LSC Responses to EPC TIS Redline Comments

Saddlehorn Ranch Traffic Impact Analysis PCD File No. SP-19-006 (LSC #184751) March 11, 2020

Figure 12  
**2043 Total Traffic,  
 Lane Geometry, and Traffic Control**  
 Saddlehorn Ranch Filing No. 2 (LSC # 184751)

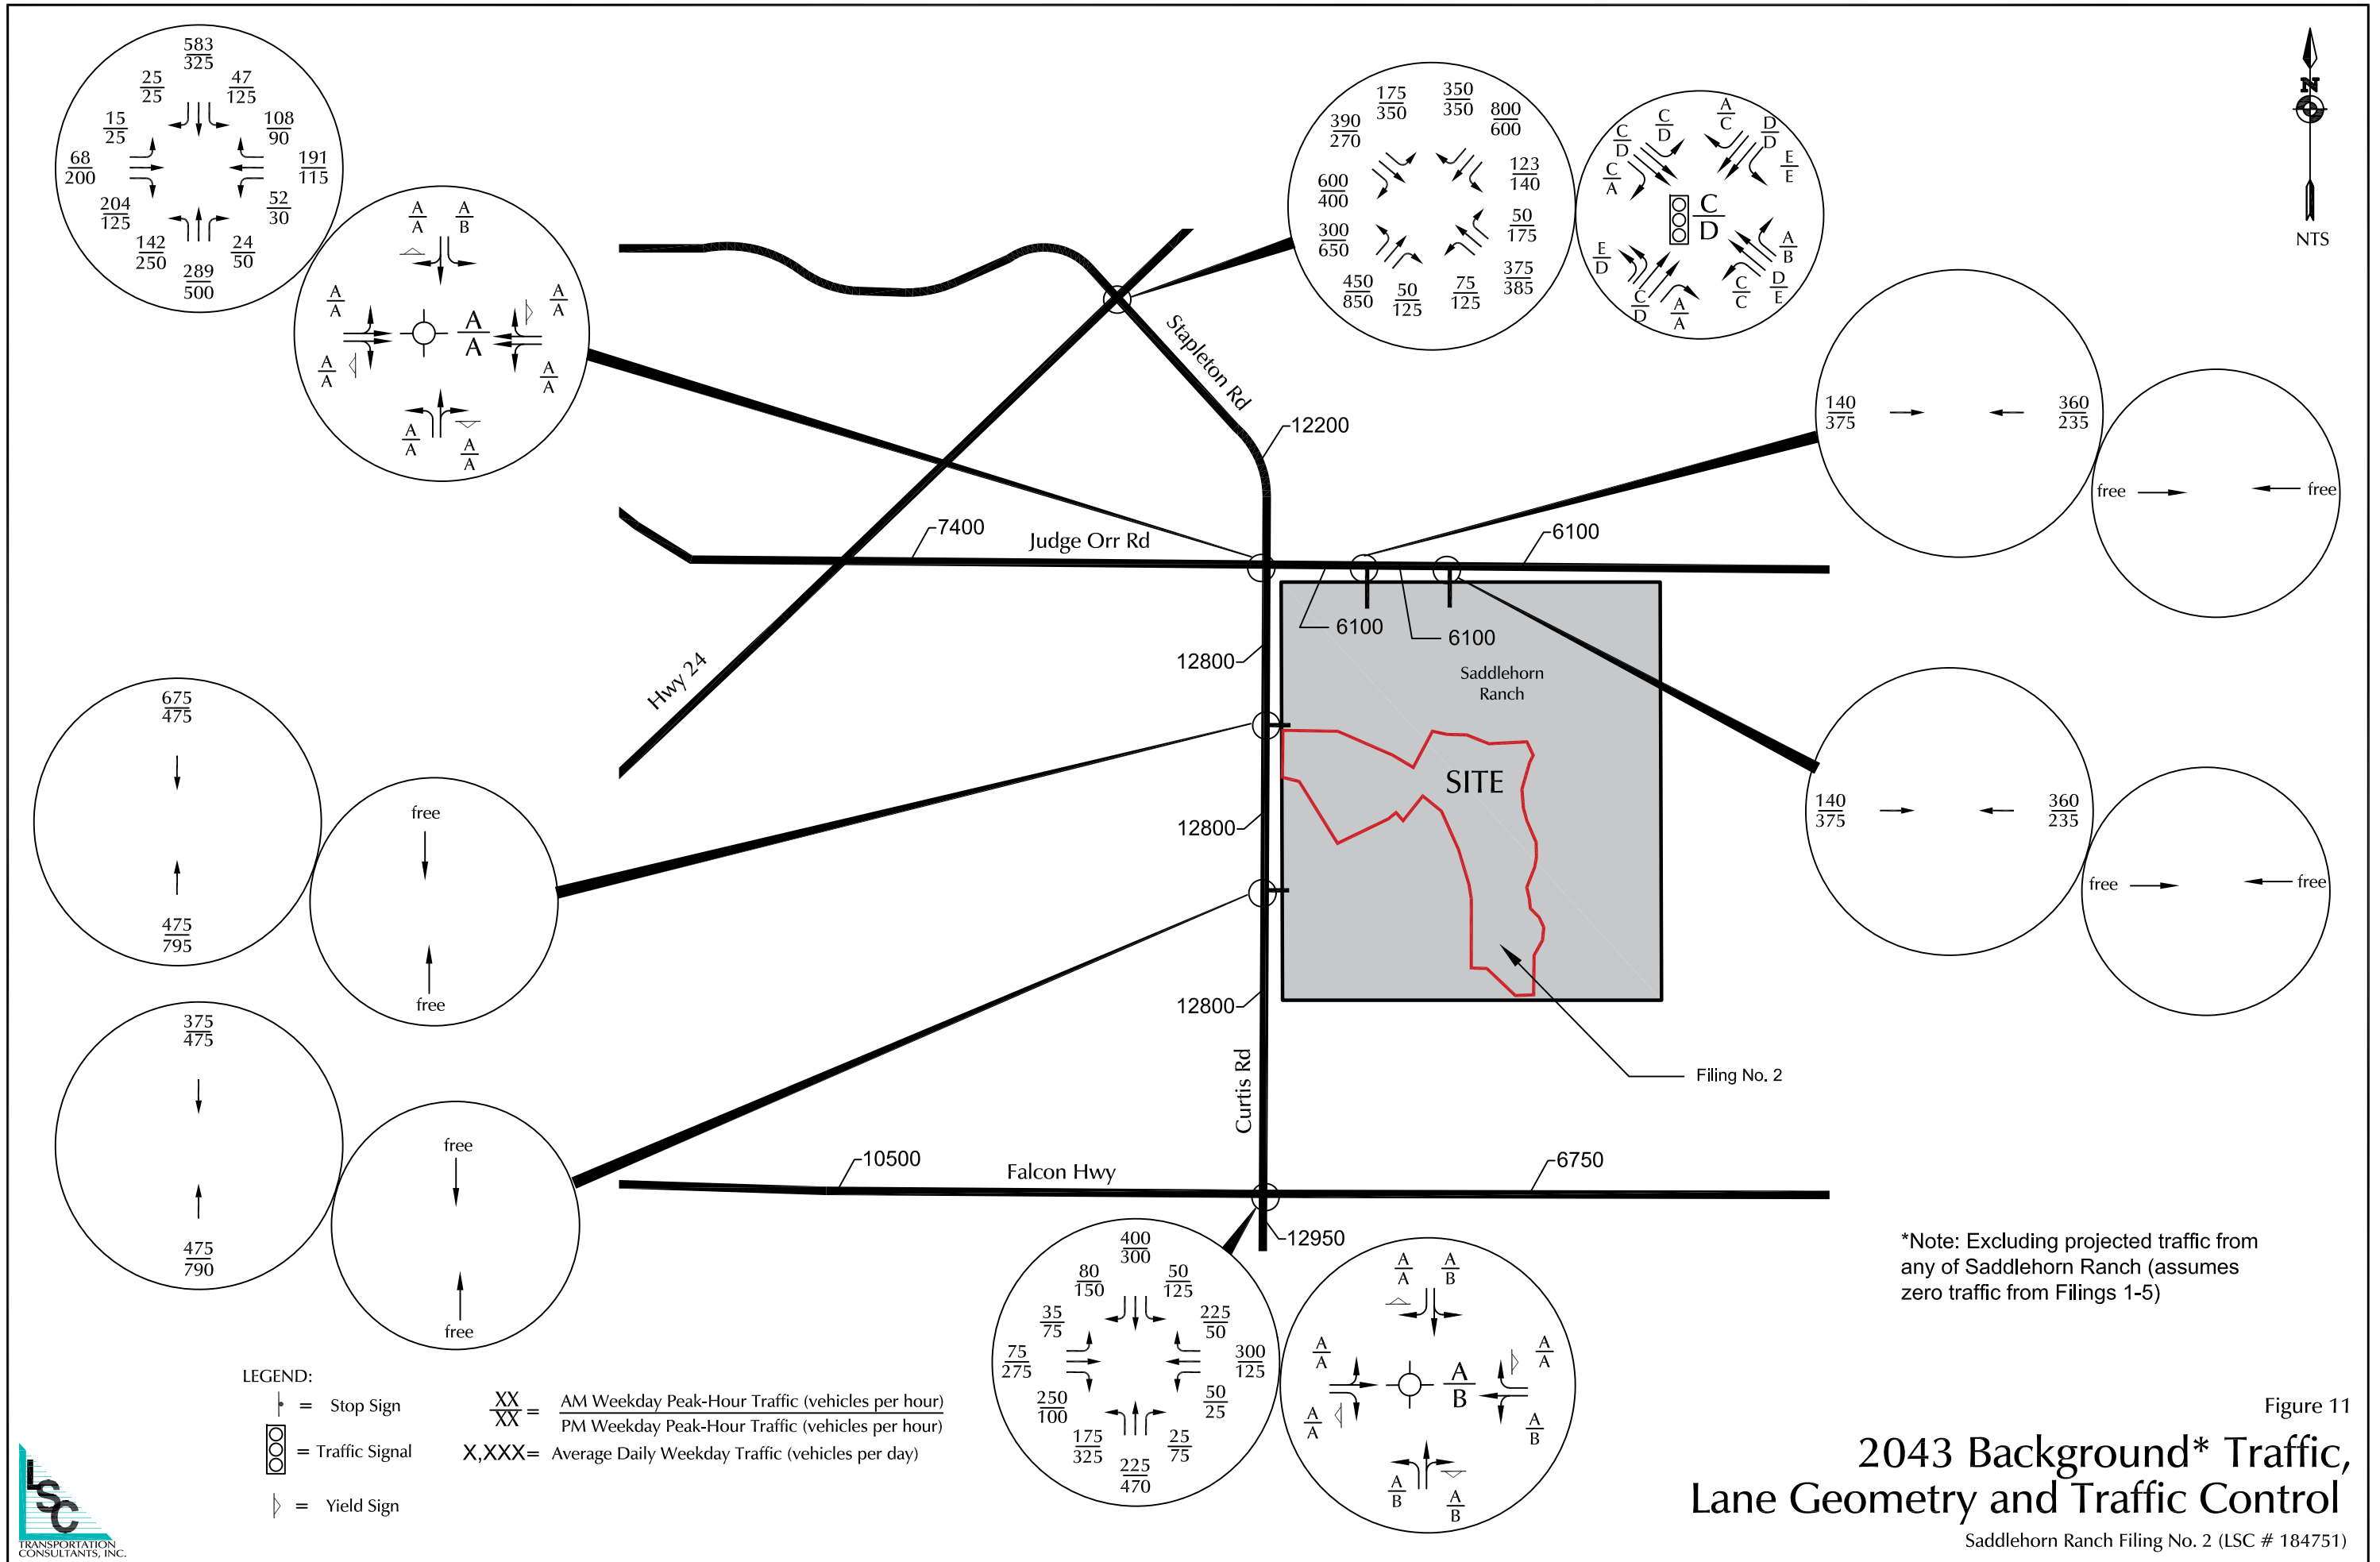
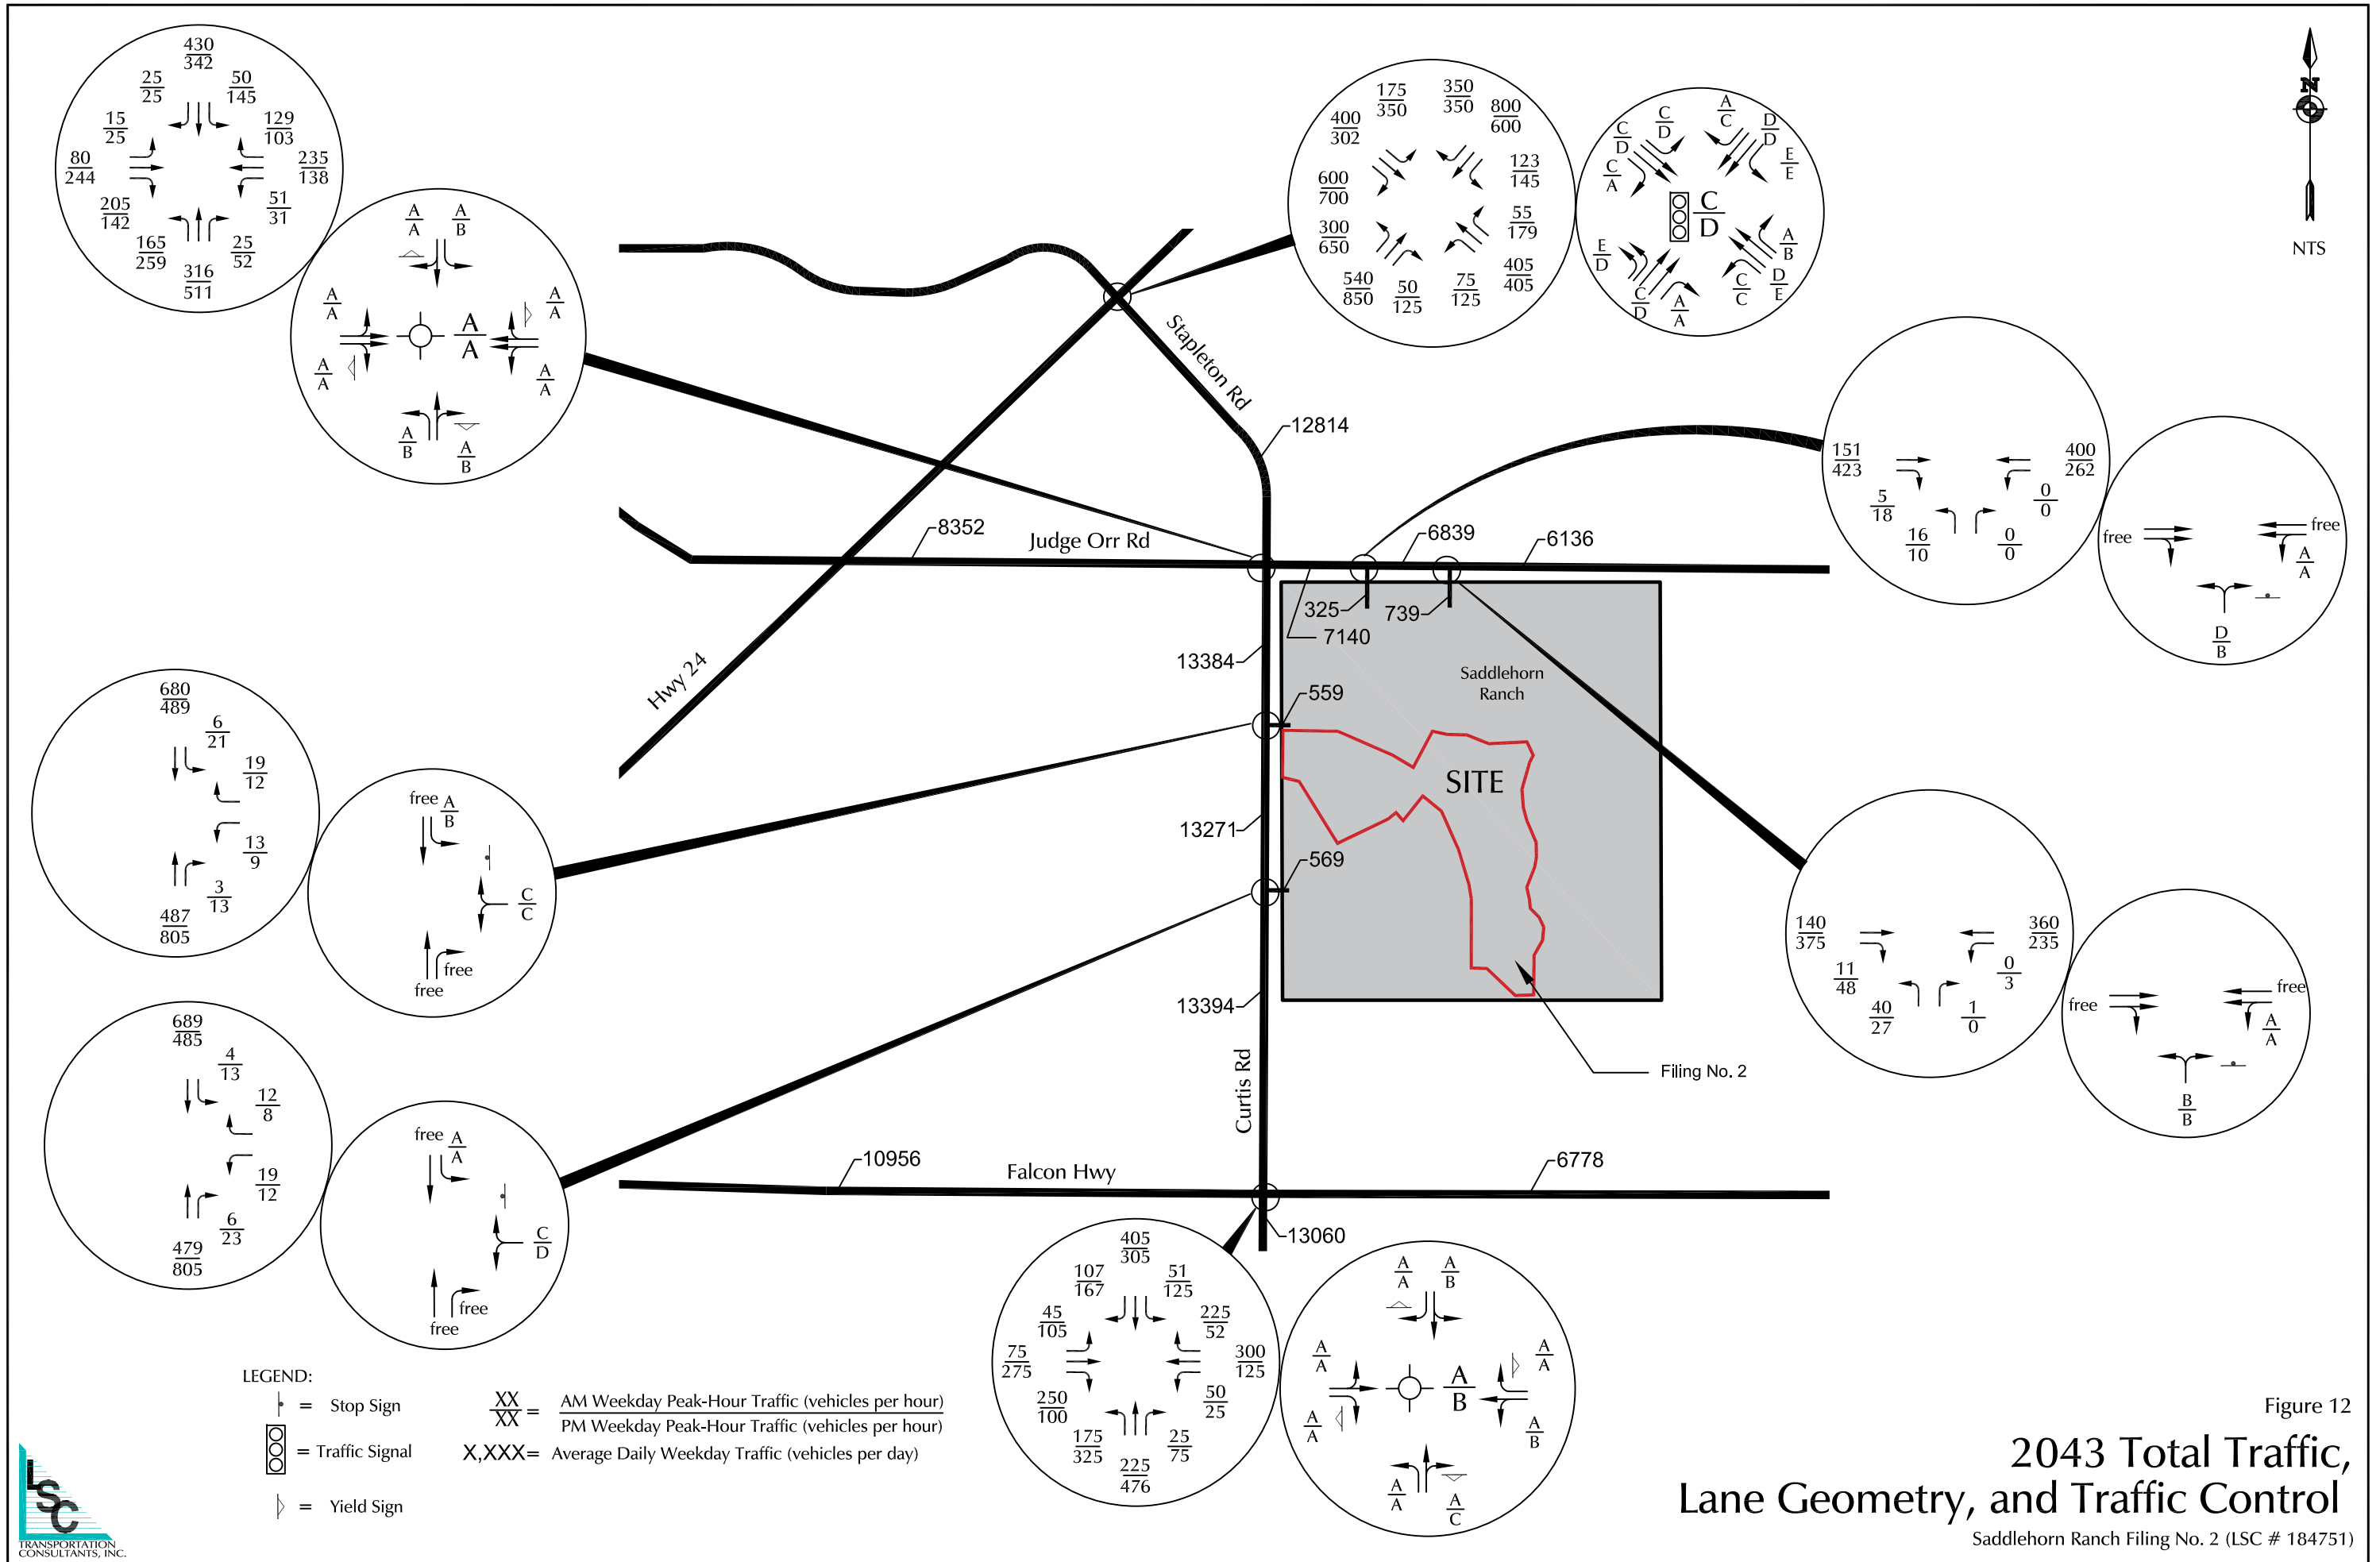
[LSC Note: This schematic has been corrected to show Yield signs instead of Stop signs.](#)
